From: Lauren Wiltshire [REDACTED]
Sent: 24 April 2019 13:43
To: Laura Gibbons <Laura.Gibbons@arun.gov.uk>
Cc: Simon Davis <Simon.Davis@arun.gov.uk>
Subject: RE: Planning Consultation on FP/42/19/DOC

Engineers Comments Regarding Condition 7

Project: Wellers Close Hampshire Homes Group	
Drawing: Soft Landscaping Concept	
Date: May 2018	Drawn by: JA
Scale: 1:200 @ A1	Revision: -

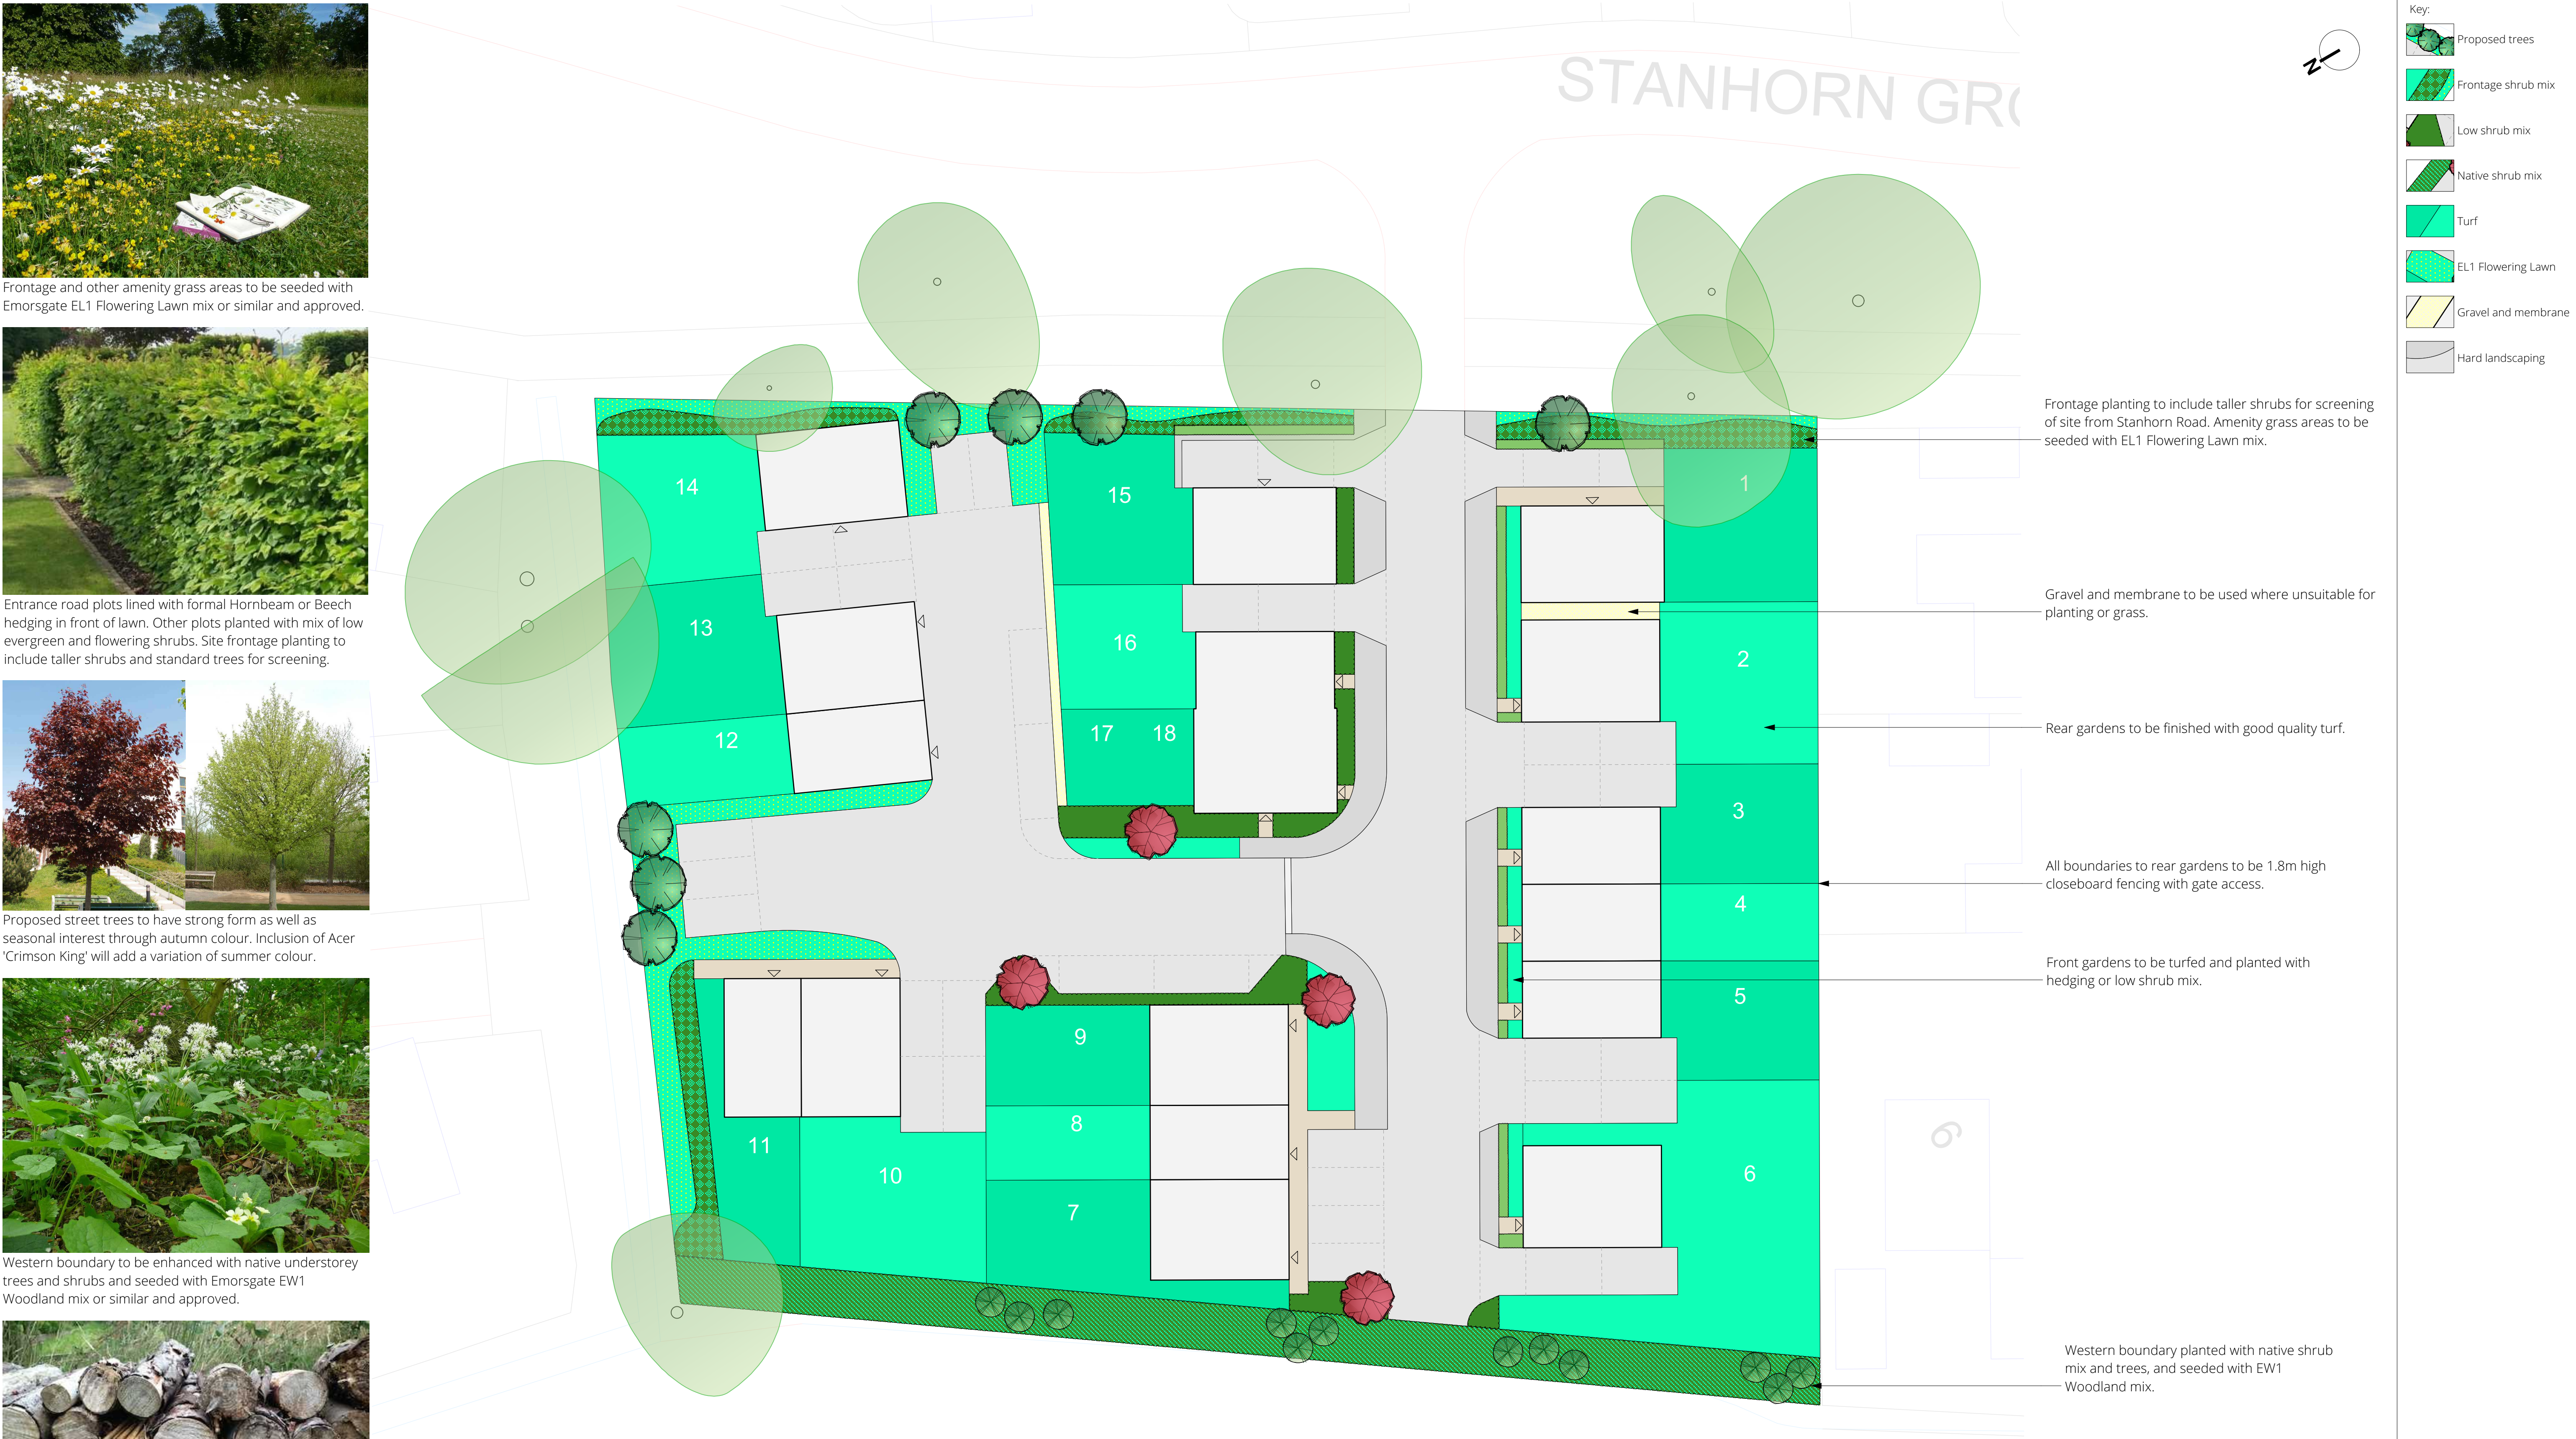
1. Catchpits must be provided upstream of all connections into the attenuation tank.
2. No construction detail drawings have been provided. Please provide construction detail drawings of manholes, catchpits, permeable paving, attenuation tank and hydrobrake.
3. There is conflict between the landscaping proposals and the drainage proposals. Trees must not be located on or near attenuation tanks. Please revise the landscaping proposals.

Rev.	Date	Note	Author	Checked
A	11/06/19	De-mountable fence indicated to rear of Plots 12 - 14	RR	JP

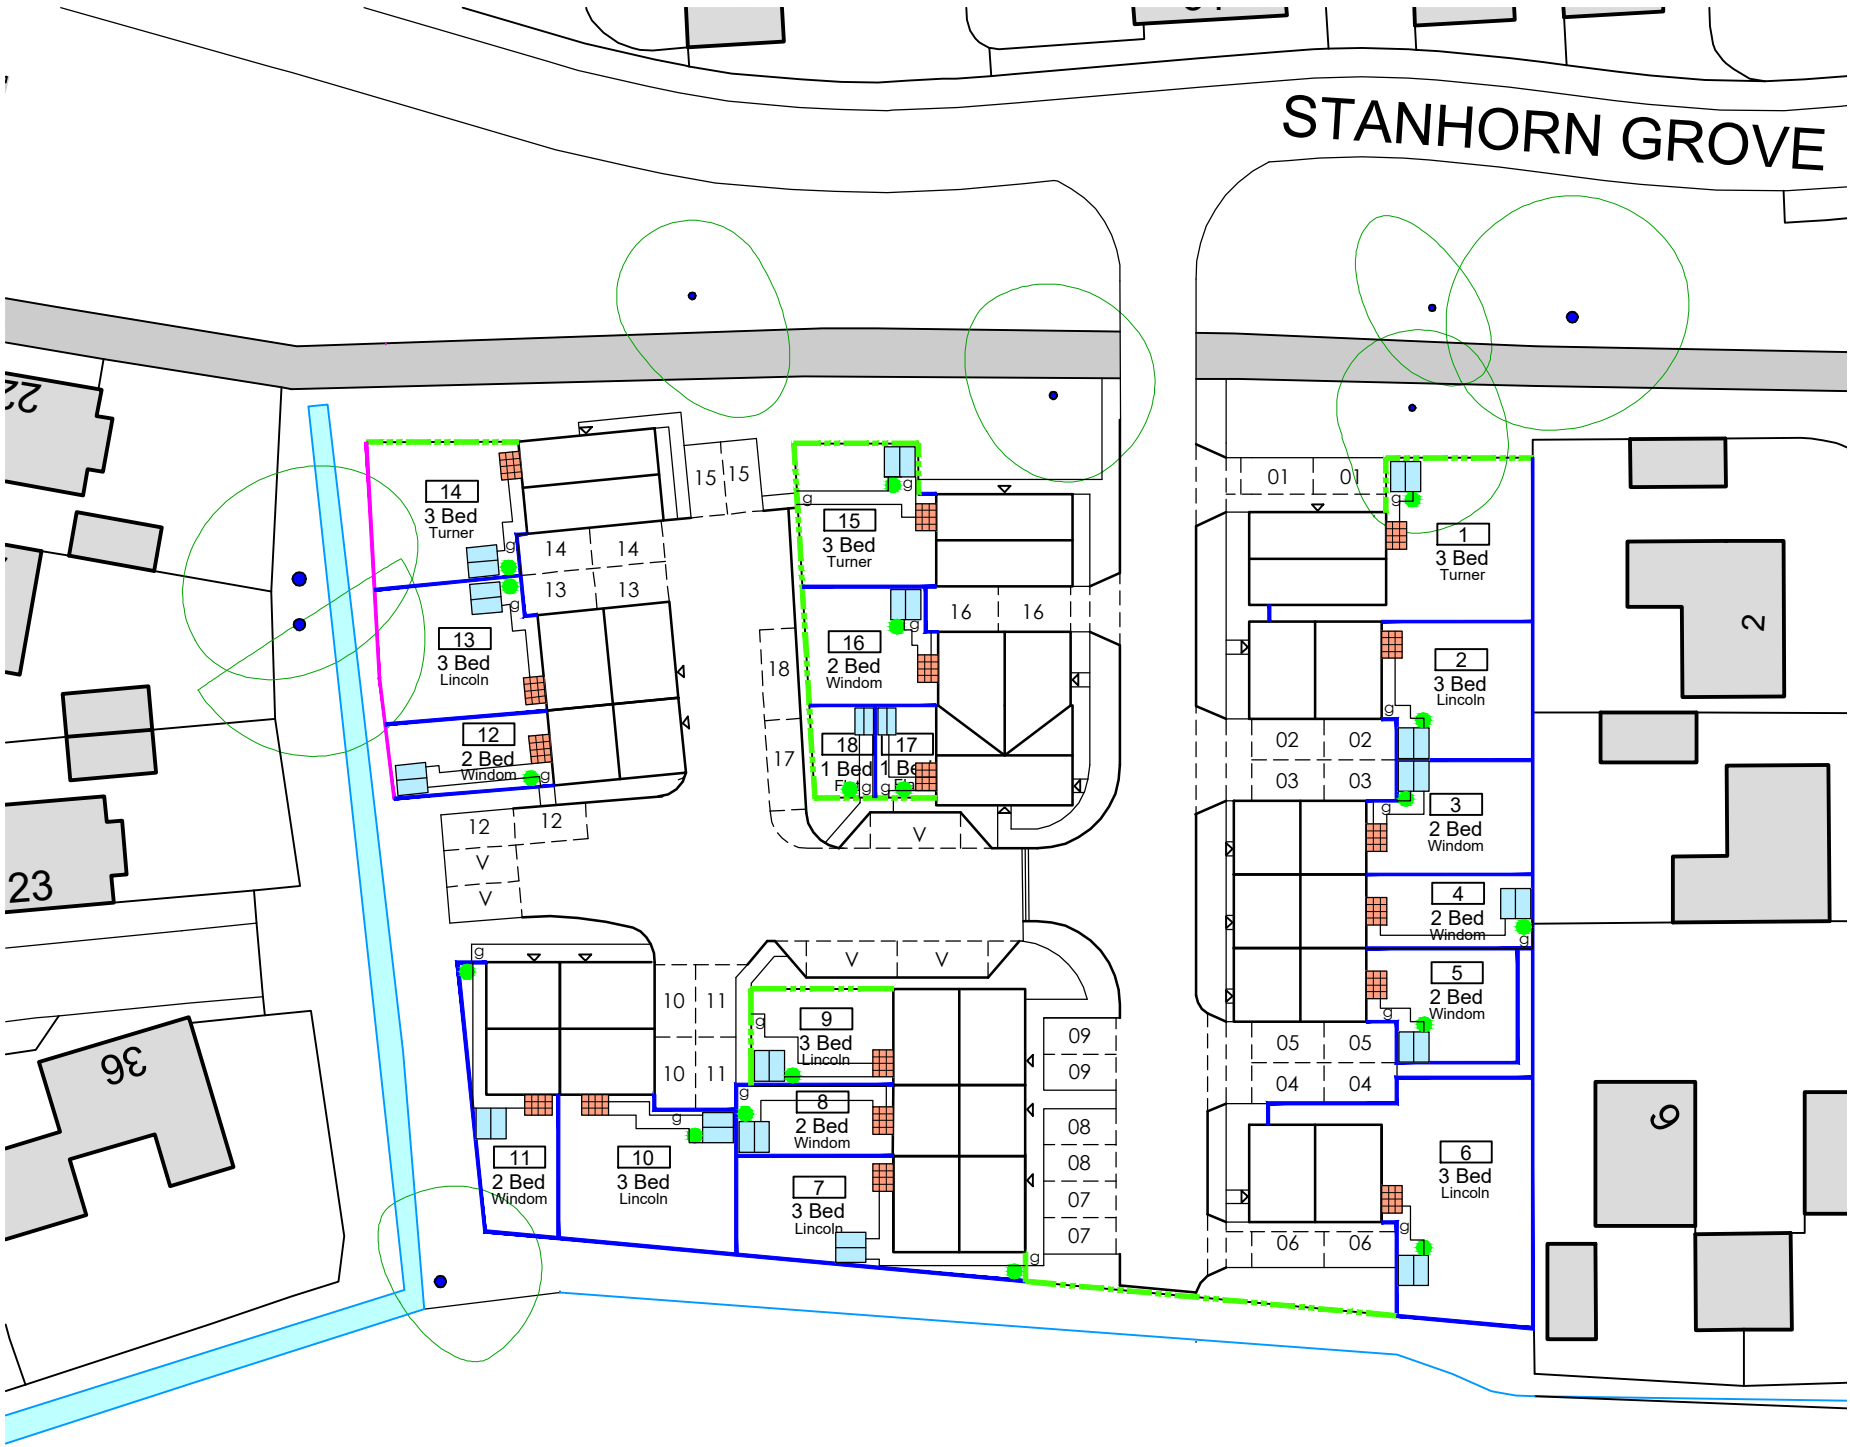
Proposed property boundaries for plots 12-14 need to be amended to allow access to the watercourse. 3m easement is required from any building, fence or wall and the top of bank of an ordinary watercourse.
